# CITY OF ALBUQUERQUE

**RE: Marie Hughes Elementary School**  
**5701 Mojave St NW**  
**Request for Temporary C. O. – Accepted**  
**Engineers Stamp Date 9/30/15 (D11D007)**  
**Certification dated: 12-13-16**

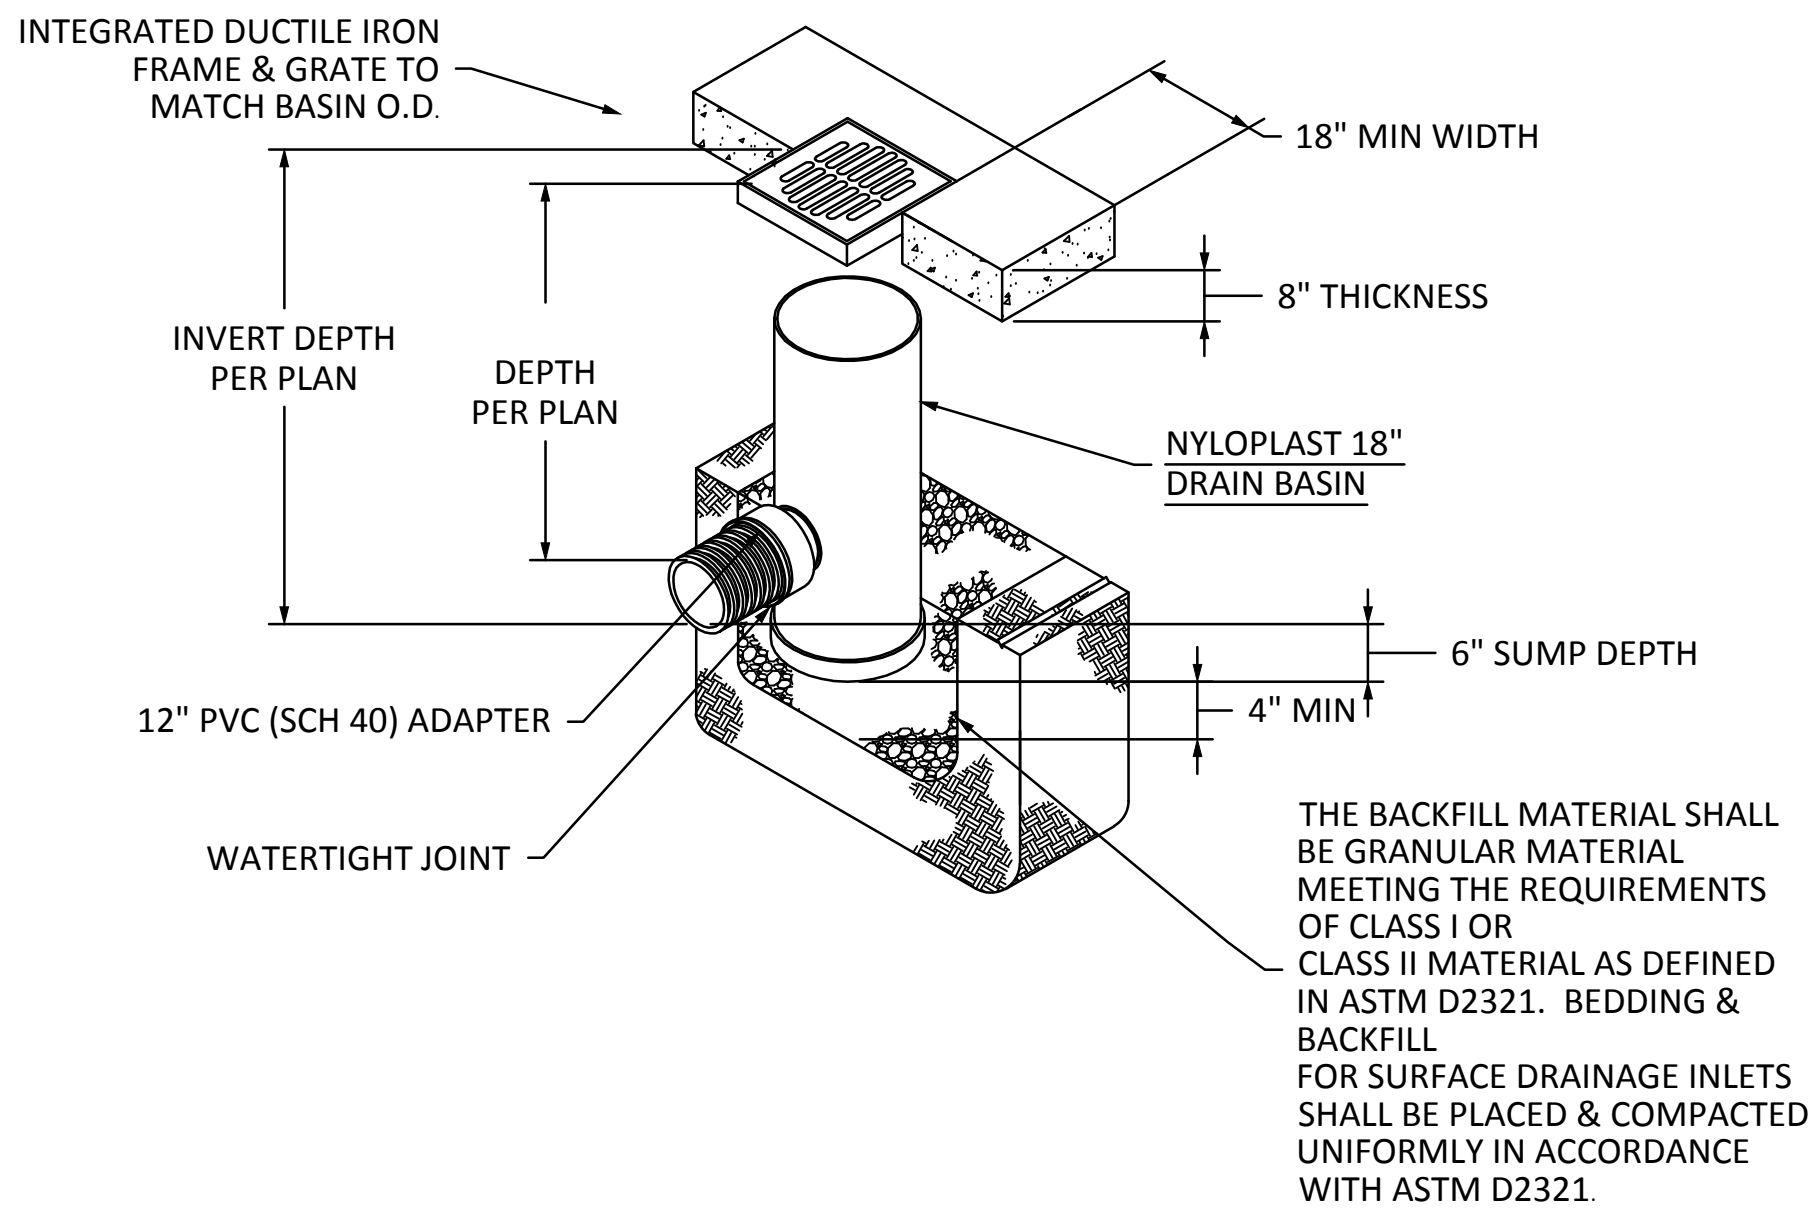
1. In the street capacity calculations:
  - ✓a. Provide a basin map showing the upstream drainage area contributing to the street flows.
  - ✓b. In the Manning's equation, show how input values are determined.

- ✓c. Show that the inlets can collect flows from the street and this development without flooding.
  - ✓d. Are inlets in a sump? Contour information is cut off.

- ✓2. The older plan by JMA in 1995 states that the outfall for this site was the Mariposa Diversion Channel, and there is already a penetration into the channel. Discharging directly into the Channel is the preferable option and should be re-evaluated. I believe there is already a penetration into the channel.

3. Analysis Points:
  - a. Provide calculations for inlet and culvert capacities shown on table in "Notes"
  - b. The 4 Analysis Points add to 6.8cfs, but the total is 32.7 cfs. Provide an onsite basin map showing the contributing flows from each basin.

- c. Show amount of flow at all discharge points – into streets, ponds, inlets, etc.
  - d. Basin Map should show how much flow is going in private storm drain system. Provide capacity calculations for the private Storm Drain.

4. How much flow is discharging into the most easterly pond (connected to inlet)? How much flow is discharging out of pond? Since it is functioning as detention pond, what is the Max WSEL? Provide calculations.

- 1a. See attached upstream basin map. ✓  
b. See attached Supporting Drainage Calculations ✓  
c. The attached calculations show street inlet capacity total to be 96.6 CFS.

d. Yes the inlets are in a sump condition as the street grade rises toward the center of the bridge crossing the Mariposa Channel. There are 6 more existing inlets across the channel.

2. There is an existing 24" wide by 18" deep concrete side inlet on the south side of the Mariposa approximately 30' upstream of the pedestrian bridge crossing. It is however buried by 3-4' deep earth and hasn't carried flow in quite some time. As the upstream end is buried its location can't be determined, but it does appear to be too high to convey flow from this site by gravity. A pump isn't desired at this location.

- 3a. See inlet and culvert capacity calculations on attached sheet.  
b. The 2<sup>nd</sup> column gives basin area (in acres), which I suspect you added to arrive at 6.8? The next to last column gives flow rate values in CFS.

c. Discharge point flow rates have been added.  
d. Sub-basins have been defined on the plan and storm drain calculations are shown on the attached calculation sheet.

4. Basin C drainage calculations have been included addressing flows into and out of the pond. A sidewalk culvert has been added for overflow purposes.

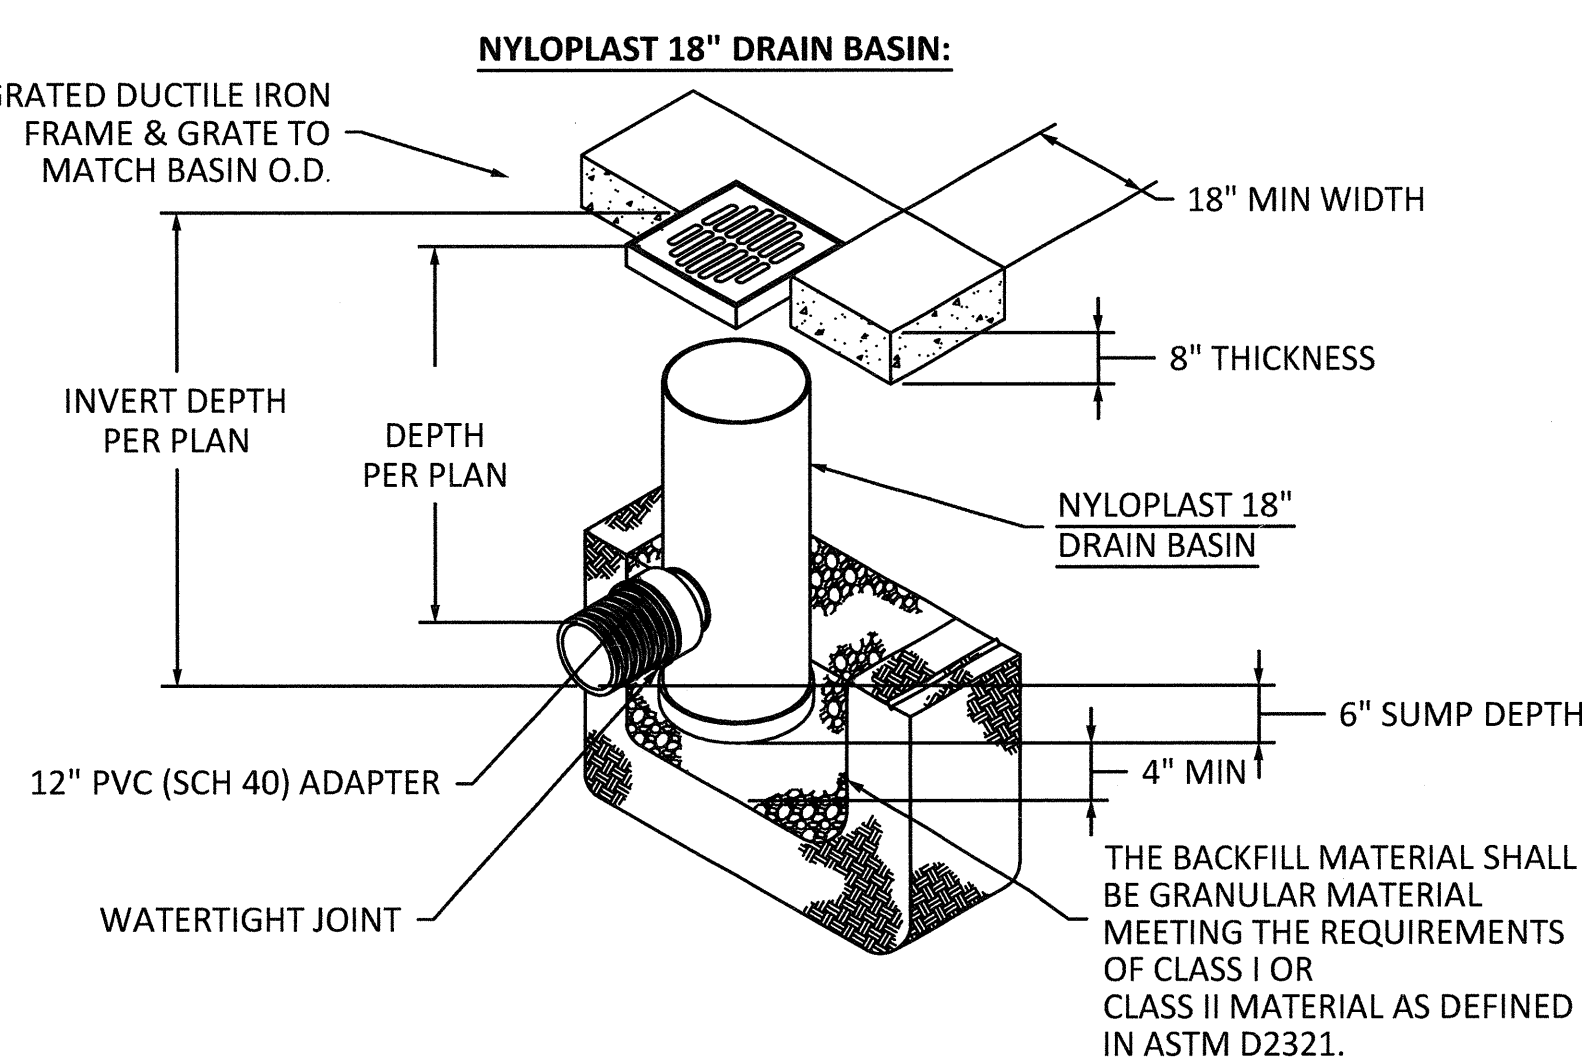
- The approved grading and drainage plans need to be as-built to reflect the work in the pond at the NE corner.
- Ensure that the utilities affected by the new retaining walls are not undermined during construction.
- Gravel needs to be placed in-between the three new trench drains in the tree wells.
- Gravel needs to be placed from the roof drain/splash block to the road at the NE corner.
- The site appears to still be under construction. Construction fences must be removed for permanent certificate of occupancy.
